DEVELOPMENT HEARING OFFICER AGENDA

June 28, 2023

7. [PR-2021-006261](#)
SD-2023-00105 – FINAL PLAT
IDO - 2021

REQUEST: FINAL PLAT APPROVAL

**NEW EASEMENTS**

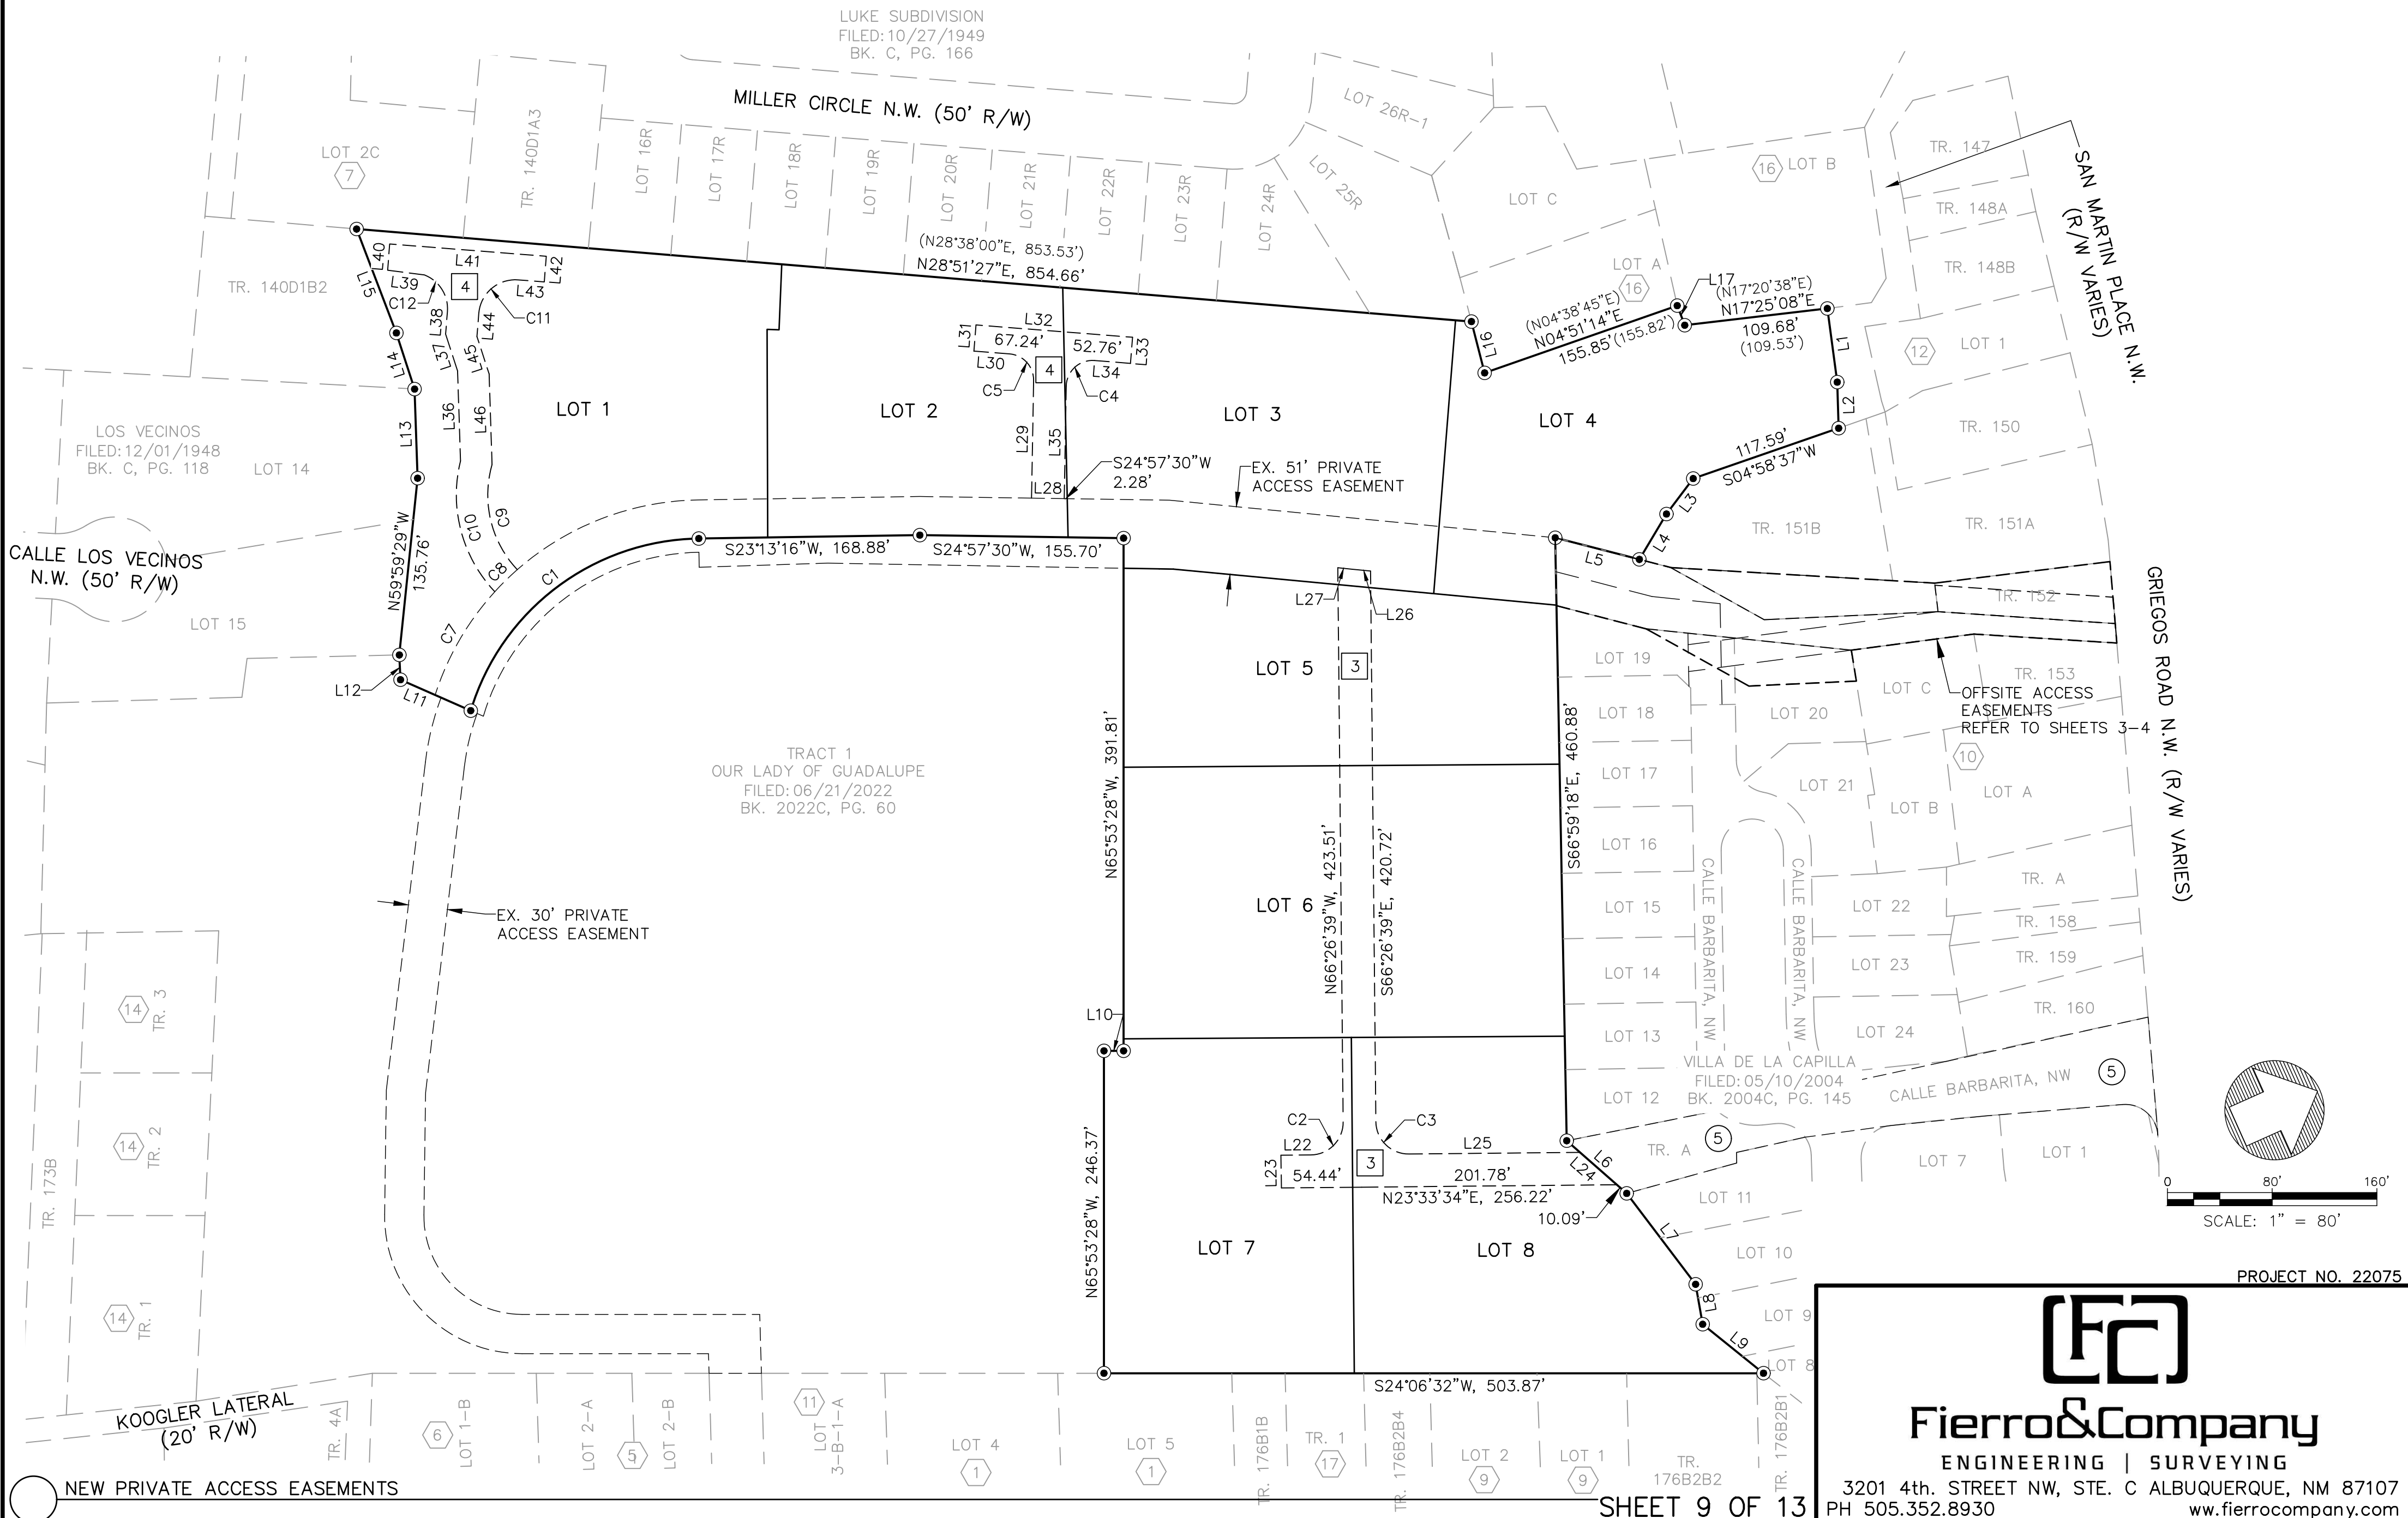
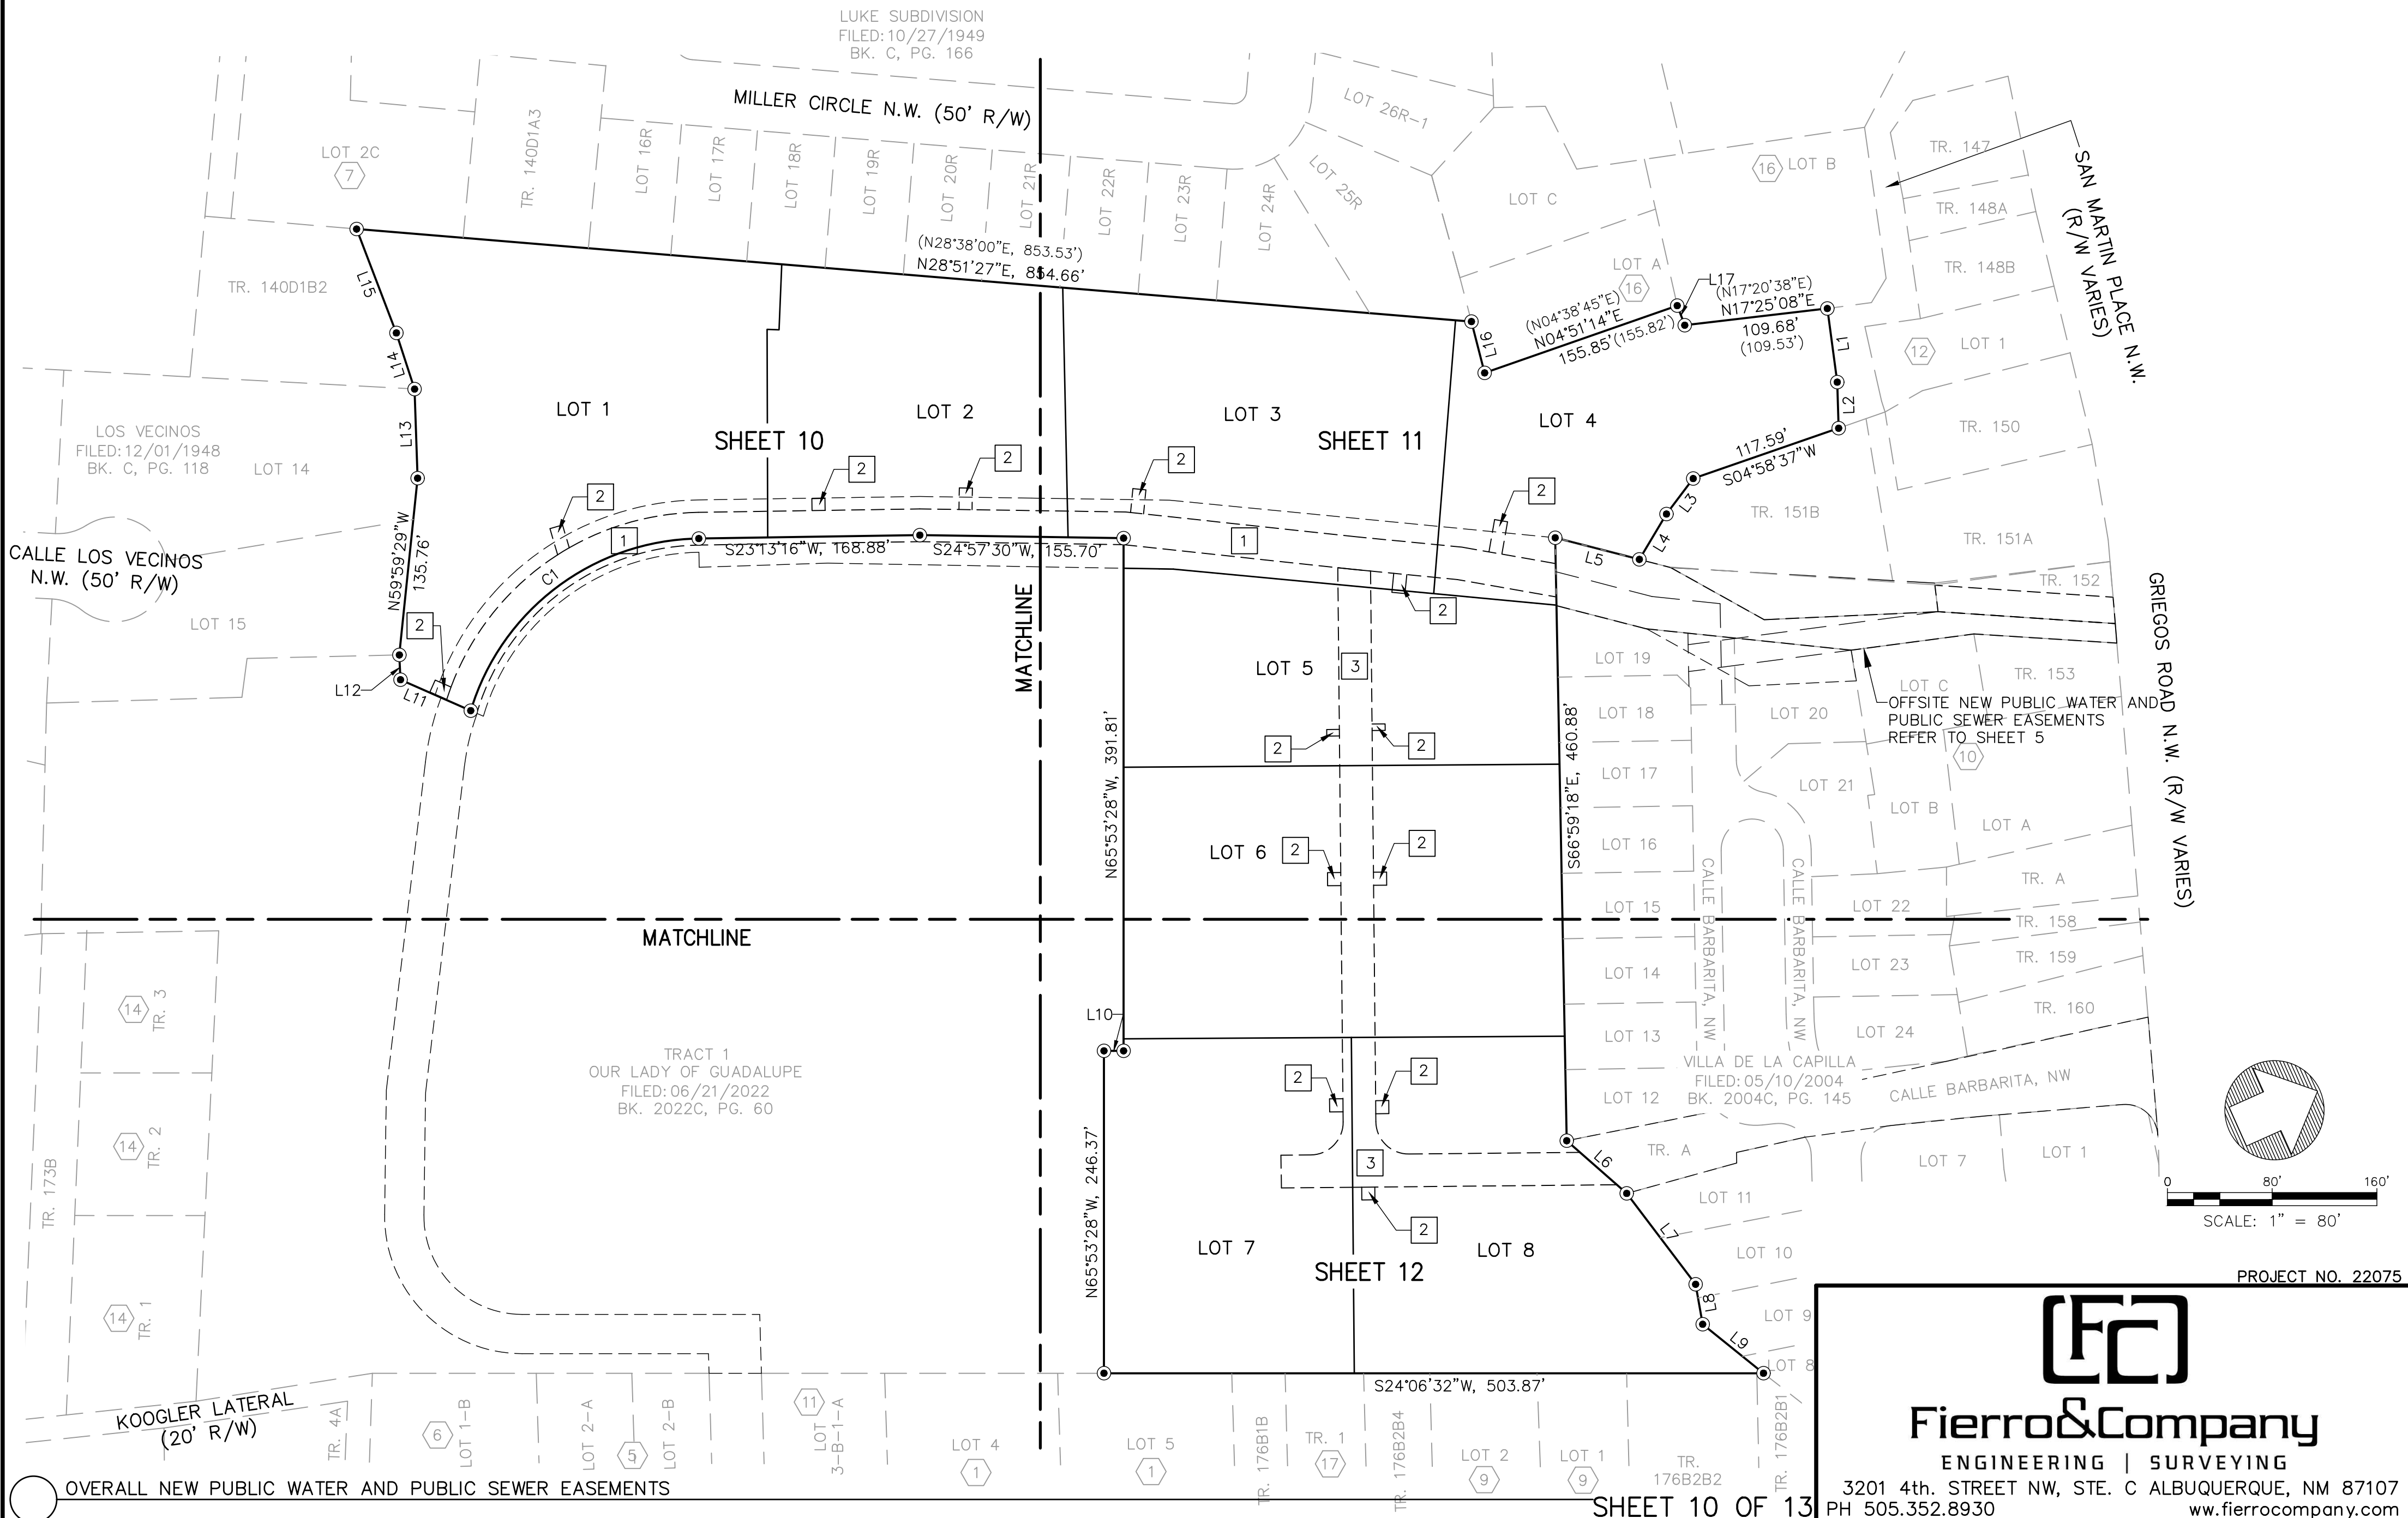
- **CONDITION 2 - EASEMENT 3 NOTED AS PRIVATE ACCESS AND PUBLIC WATER AND PUBLIC SANITARY SEWER SHOULD BE POTENTIALLY BROKEN APART AS THE PUBLIC WATERLINE AND PUBLIC SANITARY SEWER EASEMENT SHALL END AT THE EASTERN PORTION OF THE ACCESS EASEMENT AND SHALL NOT EXTEND SOUTH OR NORTH.**

- **CONDITION 3 - CALL OUT EASEMENT WIDTHS ON THE KEYED NOTES FOR PUBLIC WATER AND PUBLIC SANITARY SEWER EASEMENT CALL-OUTS.**
- **CONDITION 4 - CLARIFY THAT EASEMENT 1 IS NOT BISECTED BY TRACT 1/PROPOSED LOTS 1, 2, AND 3 PROPERTY LINES. IF SO, PLEASE SHOW THE PROPER EASEMENT WIDTHS AS APPROPRIATE AND ENSURE A MINIMUM 25' WIDTH IS PROVIDED FOR BOTH WATER AND SEWER.**
